Our reference: SF16/38066

EPA Air Technical Advisory Services Unit's comments on Proposed Lead Acid Battery Recycling Facility at 10 Lancaster Street, Ingleburn NSW

The EPA's Air Technical Advisory Services Unit (ATASU) has reviewed the Air Quality Impact Assessment (AQIA), Report Number 15225-A, Version A, dated June 2016, prepared by Wilkinson Murray Pty Limited, Level 4, 272 Pacific Highway, Crows Nest NSW 2065.

4 November 2016

**Figure 7-1 Source Location**

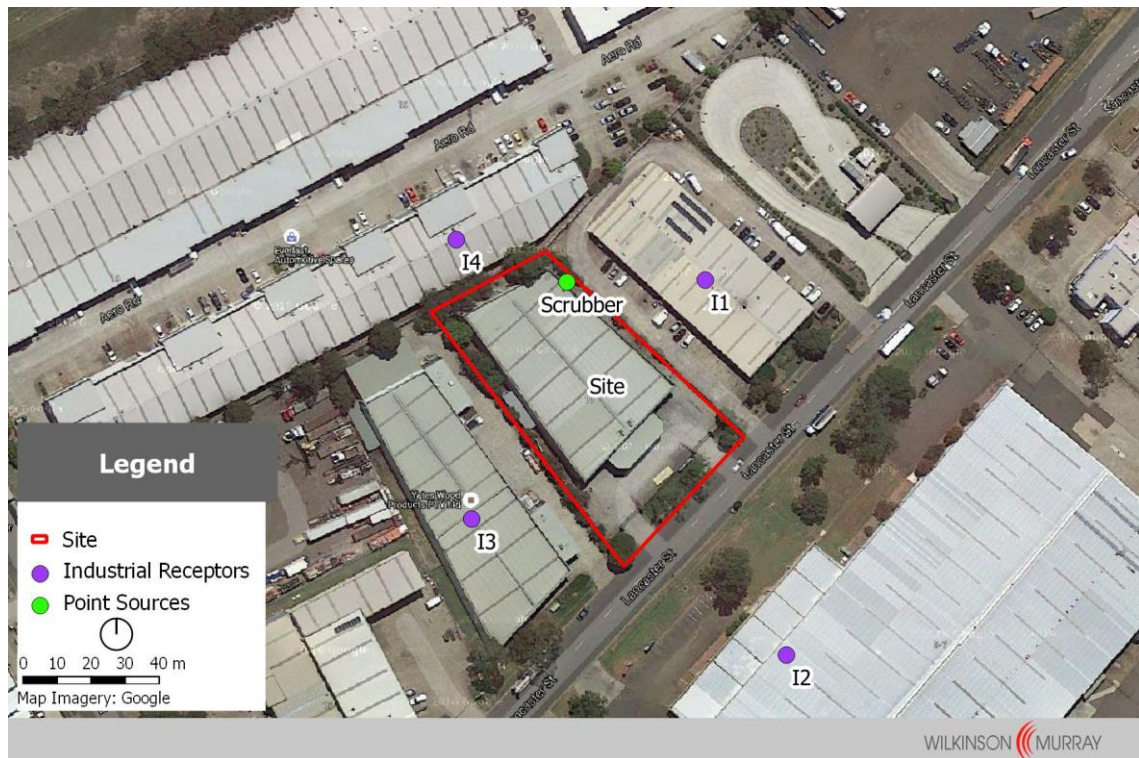
Additionally, the AQIA does not include a demonstration that the proposal will comply with prescribed limits contained in the *Protection of the Environment Operations (Clean Air) Regulation 2010*. Assurance of Clean Air Regulation compliance should be provided in the revised assessment.

Section 7.3 of the AQIA outlines the provision of sealed vessels and fugitive emission capture mechanisms with control via a wet scrubber. The EPA notes that no fugitive emissions have been accounted for within the assessment.

The EPA requests a demonstration that there are no fugitive emissions associated with the proposal through the provision of further information which details:

- The unit operations that include the fugitive emission capture mechanisms;
- The unit operations that are proposed to be sealed;
- The mitigation measures for handling the outputs (specifically those containing lead) from the process, and the provision of fugitive emission capture and control mechanisms; and
- If the building is proposed to be designed and operated under negative pressure.

Section 7.3 of the AQIA states “*When transferring the electrolyte to a tanker truck, a vapour return line should be connected between the tanker truck and the on-site electrolyte storage vessel in order to capture any vapours from the tanker truck that are displaced during transfer*”. The EPA notes that the assessment has not included any emissions during transfer of the sulfuric acid. The EPA requests clarification on the incorporation of the vapour return line in to the project design.

**Figure 8-1 Ground Level Concentration Contours – 24-hour Average PM<sub>10</sub>**

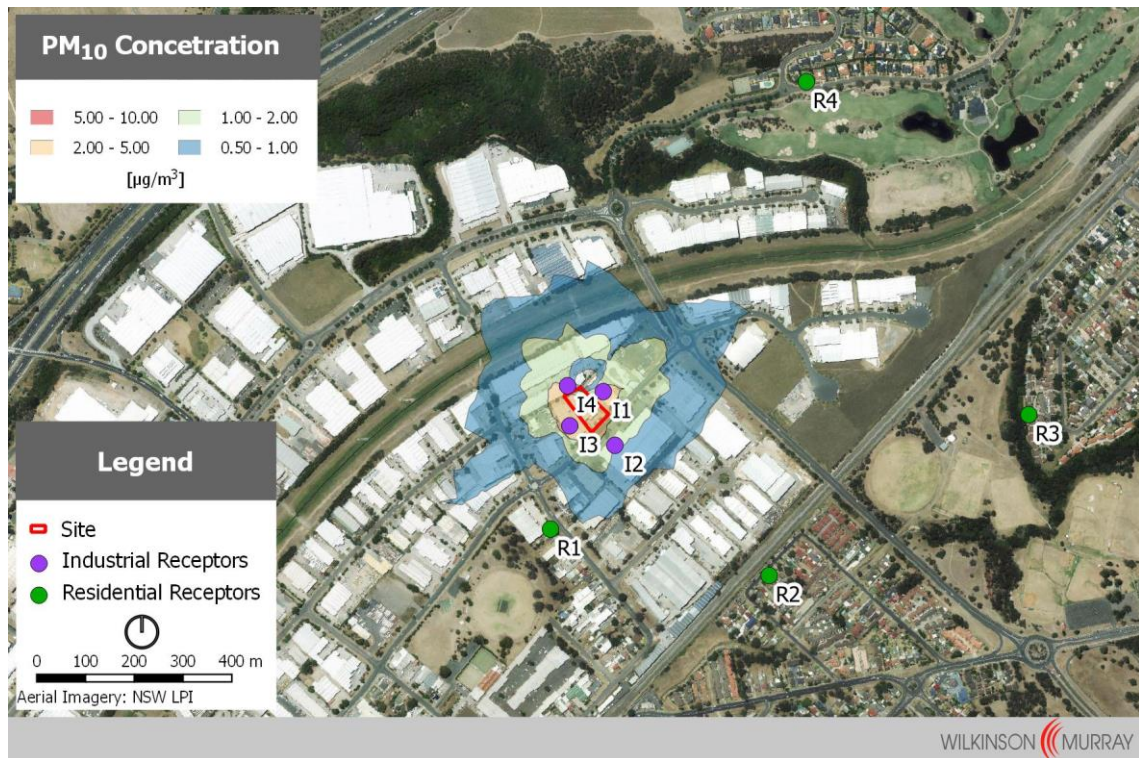
The assessment includes comparison of the predicted ground level concentrations (GLC) of sulfuric acid against impact assessment criteria at assessed discrete receptors. EPA notes that the impact assessment criteria for sulfuric acid applies at and beyond the boundary of the facility.

The assessment should be revised to include the maximum predicted GLC for sulphuric acid across the modelling domain to confirm no predicted impacts at or beyond the site boundary.
